**CITY OF ALBUQUERQUE  
PLANNING DEPARTMENT  
September 25, 2013  
DRB Comments**

**PROJECT # 1009835**

**RE: Lots 37 - 41, Block 8, Palisades Addition**

**PLAT OF
LOT 41-A, BLOCK 8
PALISADES ADDITION**

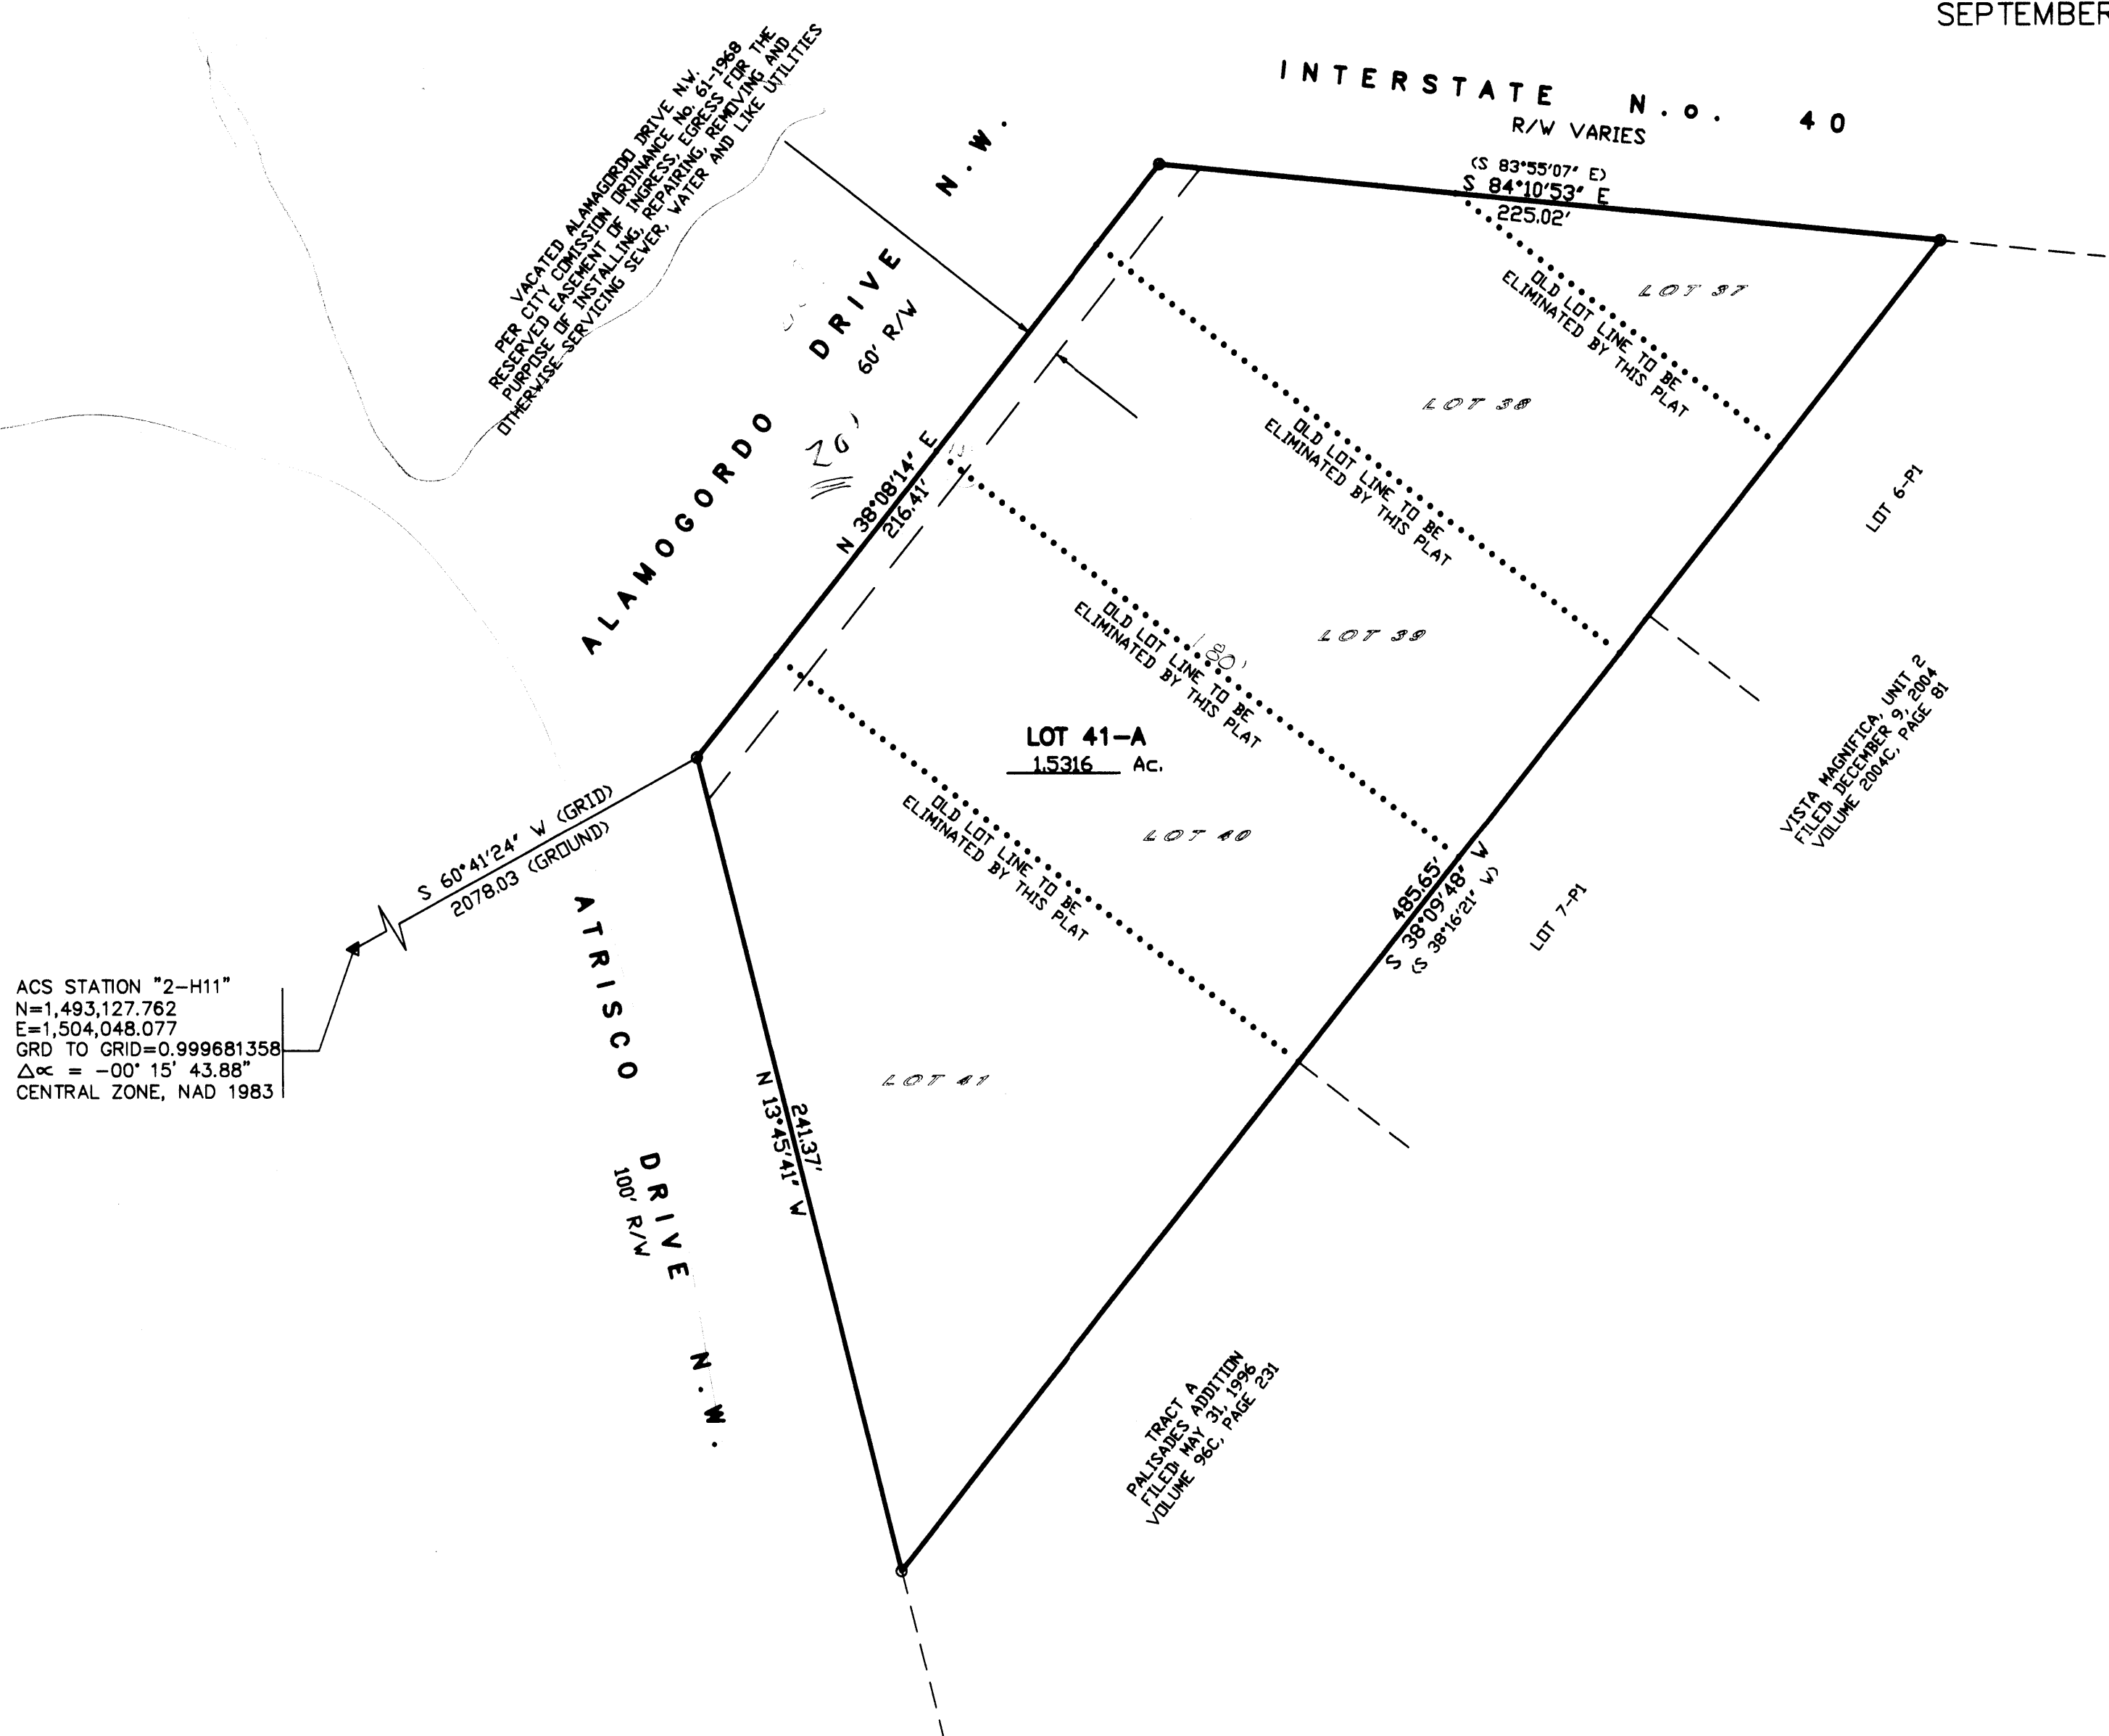
A copy of the Vacation Ordinance 61-1968 needs to be provided for the file, and Property Management needs to sign off on the plat for final approval. It appears infrastructure may be required if right of way is remaining for Alamagordo.
